MEMORANDUM

TO: Jean Fraser
FROM: David Senus, P.E. & Ashley Auger, E.I.T.
DATE: June 15, 2011
RE: Harborview Townhouses, Level III Final Site Plan Application

Woodard & Curran has reviewed the Final Level III Site Plan Application for the Harborview Townhouses located at 127-129 York Street in Portland, Maine. The project includes the construction of a new three story 4,160 square foot (footprint) building to house seven new residential units on an urban infill lot, along with associated site improvements.

1 RECONSTRUCTED BRICK DRIVEWAY APRON LAYOUT  
NOT TO SCALE  
L3.0

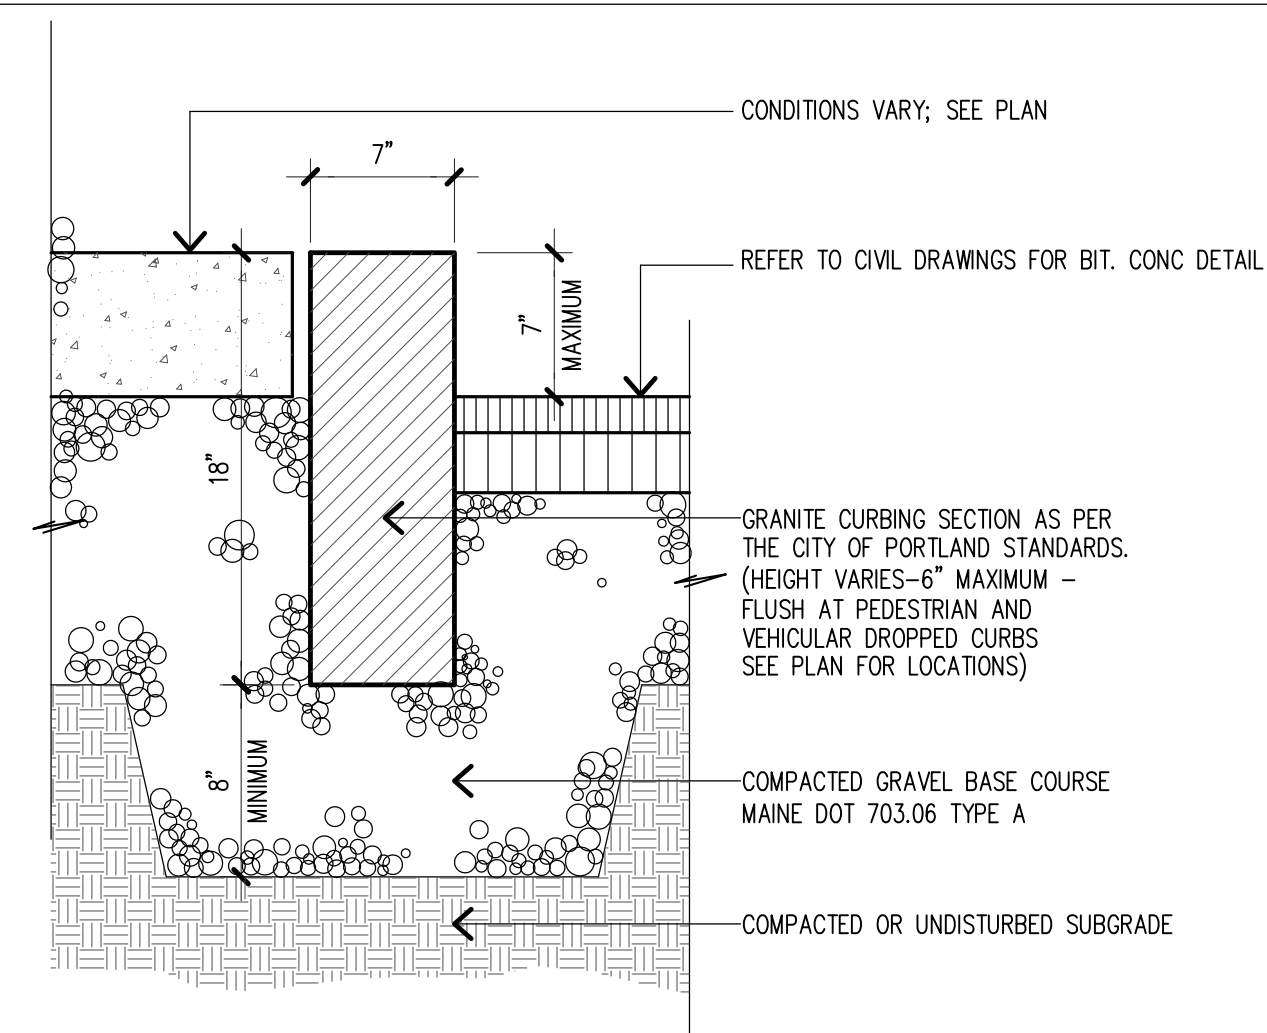
- The proposed driveway entrance is shown on the plans with radial curbing. The detail provided on sheet L3.0 for the Reconstructed Brick Driveway Apron Layout does not indicate the use of radial curbing. The applicant should clarify the type of curbing and modify the plans or detail to reflect the correct curbing layout.
